M54 to M6 Link Road

**8.8 P(B) Draft Statement of Common
Ground with Natural England**

Version	Date	Status of Version
6 (P08)	January 2021	Issue to the ExA for Deadline 4

Plot Date: 24 January 2020 13:23:07
File Name: I:\Workspace\Stage 3 Figures\Landscape and Environment - Air Quality\HE514465-ACM-EGN-M54_SW_PR_Z-DRLA-0001 - Figure 5.1 - Air Quality Study Area.mxd

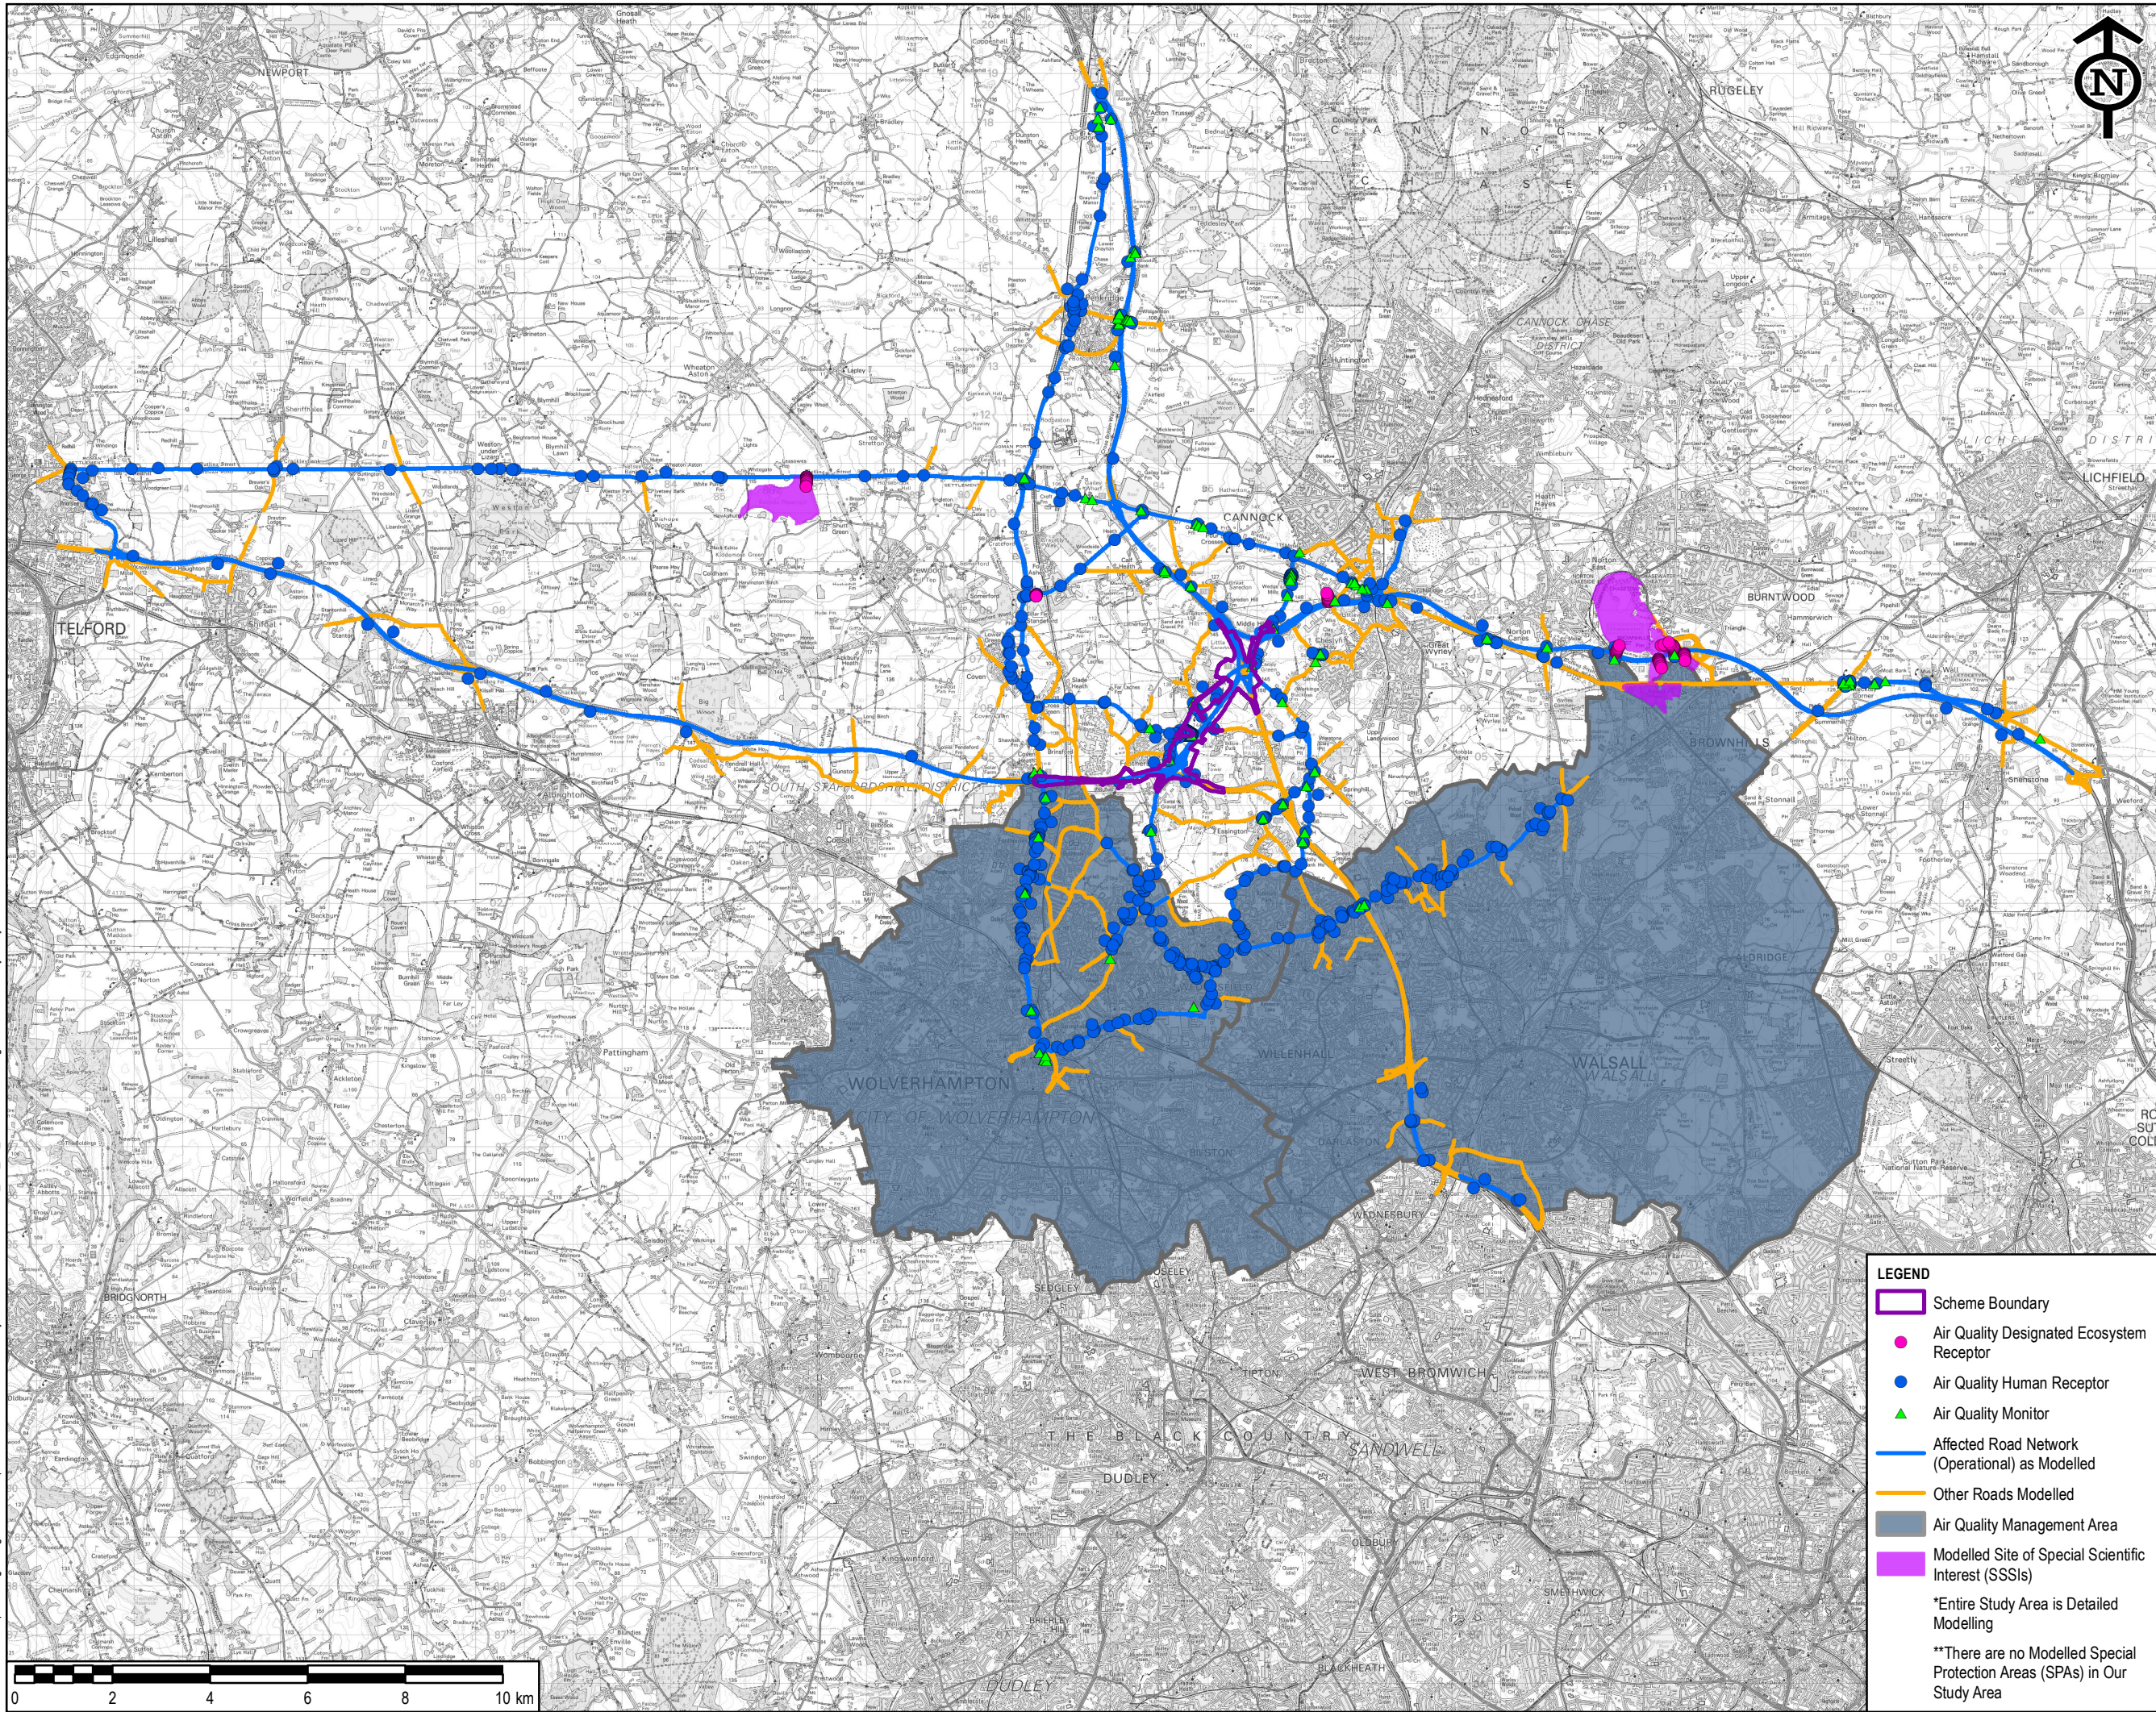
<p>HRA Screening Assessment</p> <p>RR-037an</p> <p>IR: NE-07</p>	<p>HRA [APP-216/6.9]</p> <p>Para. 3.1.9 to 3.1.12</p>	<p>From the ES information provided we are not clear how the ARN was identified or the rationale for other roads being included in the model and associated air quality assessment (reference – ES Chapter 5 - Figure 5.1 Air Quality Study Area).</p>	<p>The local operational air quality assessment considers the impact on individual sensitive receptors at distances of up to 200 m from the ARN based on guidance presented in DMRB HA207/07. In this approach the receptors with the highest predicted concentration and biggest predicted change in pollutant concentration are considered. This is because the effect of pollutants from</p>	Agreed	Agreed	Agreed

Issue ³	Document	Natural England comment	Highways England response	Status	Agreement likely ⁴ (app)?	Agreement likely (IP)?
			<p>road traffic reduces with distance from the point of release. Beyond 200 m these pollutants are likely to have reduced to a concentration equivalent to background concentrations. This is set out in Paragraph 5.3.5 of the ES [APP-044/ 6.1].</p> <p>The methodology for defining the ARN is set out in Section 5.5 'Study Area' of the ES [APP-044/6.1]. Paragraph 5.5.2 of the ES states "<i>Affected road links (individually modelled sections of road) have been identified by comparing traffic data with the Scheme (Do-Something) and without the Scheme (Do-Minimum) against the local air quality screening criteria presented in DMRB, which are as follows:</i></p> <ol style="list-style-type: none"> 1) road alignment would change by 5 m or more; or 2) annual average daily traffic (AADT) flows would change by 1,000 or more; or 3) heavy duty vehicles (HDV) (vehicles greater than 3.5 tonnes, including buses and coaches) flows would change by 200 AADT or more; or 4) daily average speeds would change by 10 km/hr or more; or 5) peak hour speed would change by 20 km/hr or more." <p>The 'Other Roads Modelled' illustrated on Figure 5.1: Air Quality Study Area [APP-068/</p>
